Planning Application Ref: BE/38/19/PL

Location: Adjoining site at 10 Acre Field West of Saltbox, Rowan Way, Bognor Regis

Description of works: Creation of temporary soil storage bund associated with development of adjoining site at Salt Box

Tree Officer / Parks and Greenspace Team

TOP SOIL RELOCATION
SITE PLAN
1744-TS-P02-A
1:1250 @ A3
12.02.19
DRAWN BY

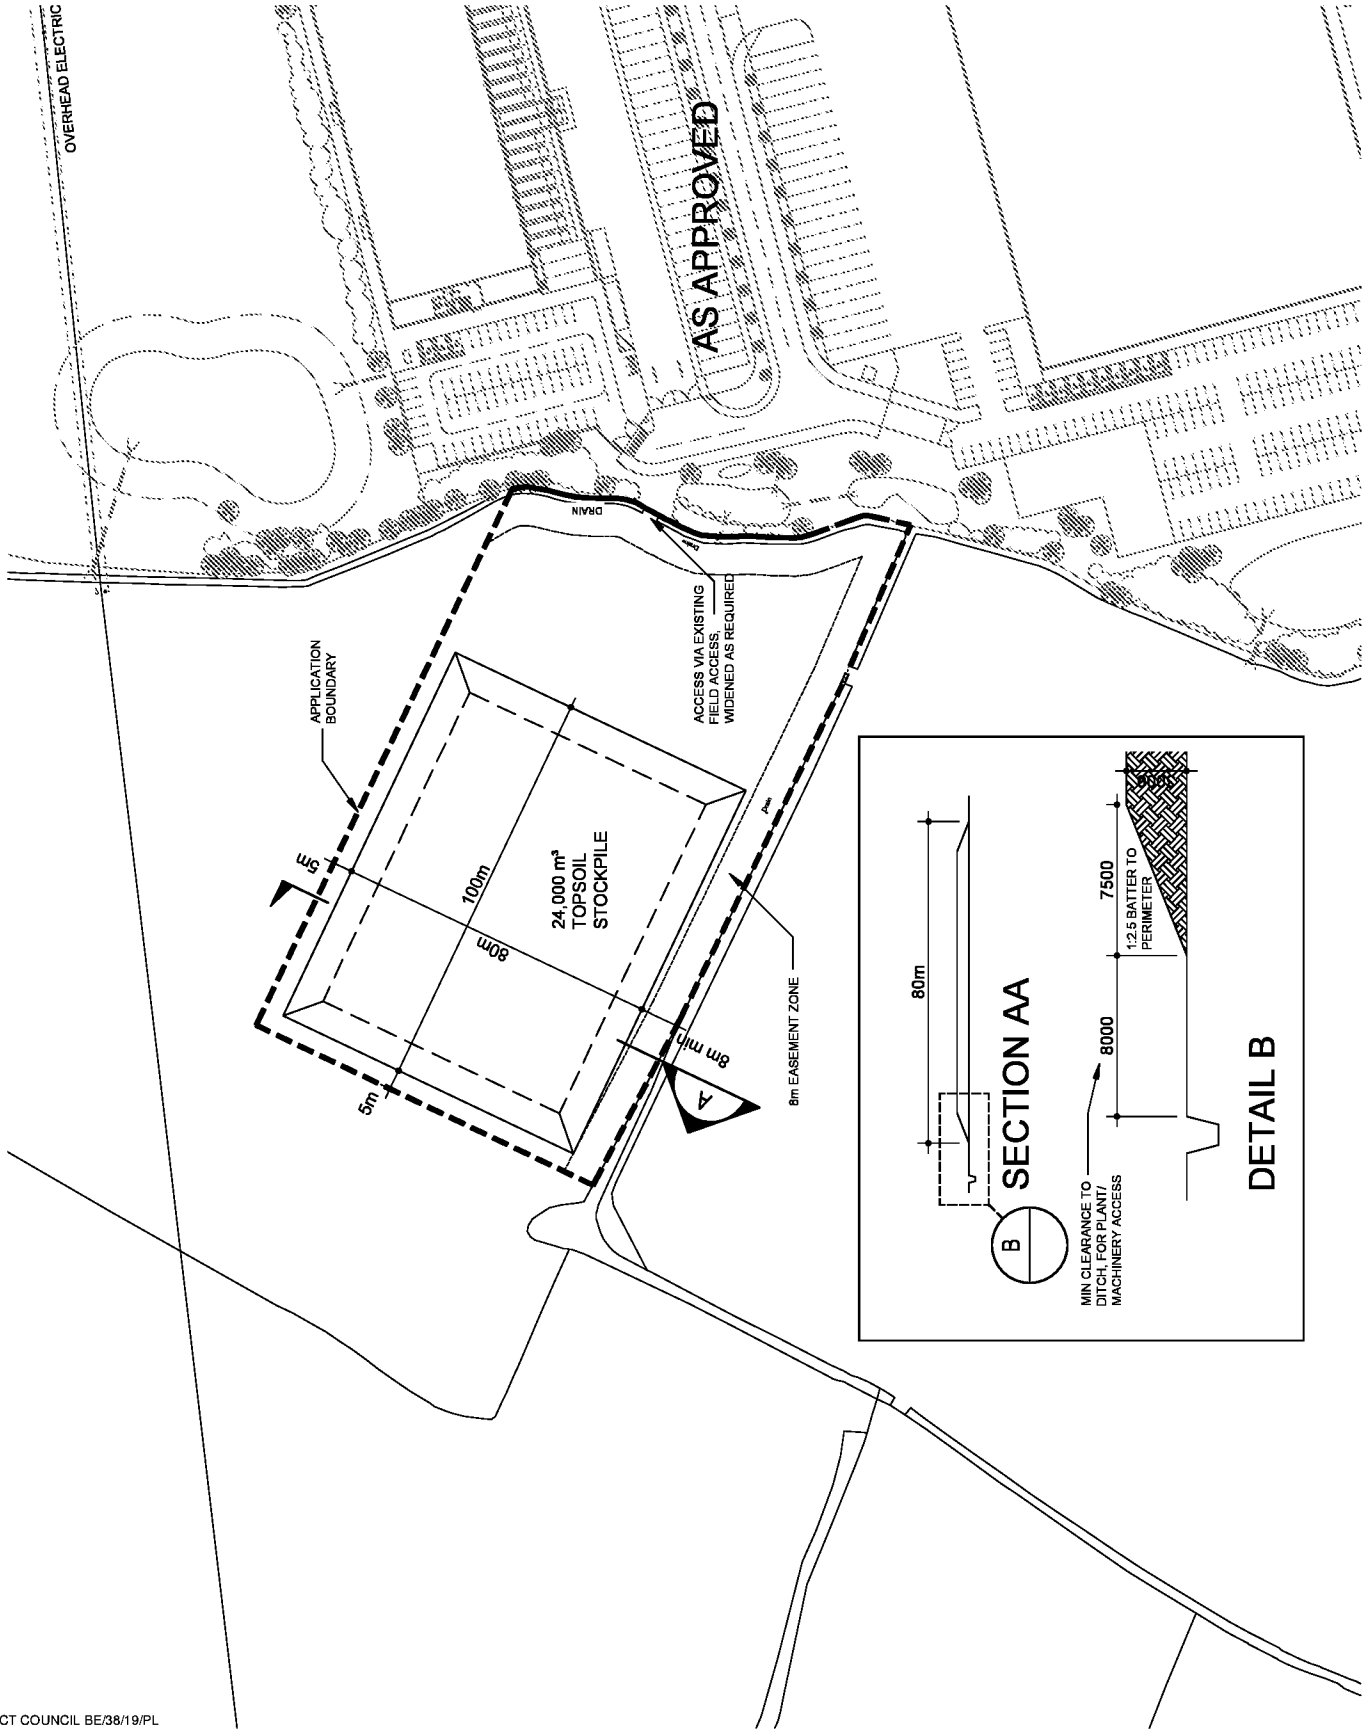
- The top soil relocation site plan suggests adequate buffer zones will be in place to protect those boundary trees and hedgerow, but this has not been confirmed with detail.

- The widening of the existing field access to accommodate heavy plant traffic will involve some removal of vegetation. This has not been described in detail, so we cannot appreciate the full impact. It is unlikely to be problematic but should be established prior to commencement.

- The applicants will need to employ the services of an Arboricultural Consultant to carry out a tree survey exercise and then prepare a brief Arboricultural Report which must be inclusive of; a 'Tree Survey Schedule' and a 'Root Protection Area (RPA) Schedule' – with the trees accurately plotted on same.
- In the event that a RPA of any tree which is proposed for retention overlaps the development then BS5837:2012 requires that the Detailed Planning Application is accompanied by an Arboricultural Method Statement (AMS) and also most importantly a Tree Protection Plan – to both describe and illustrate the mitigation measures which are to be employed to ensure that the trees survive without detriment to their vigour and vitality and are given adequate protection both above and below ground.
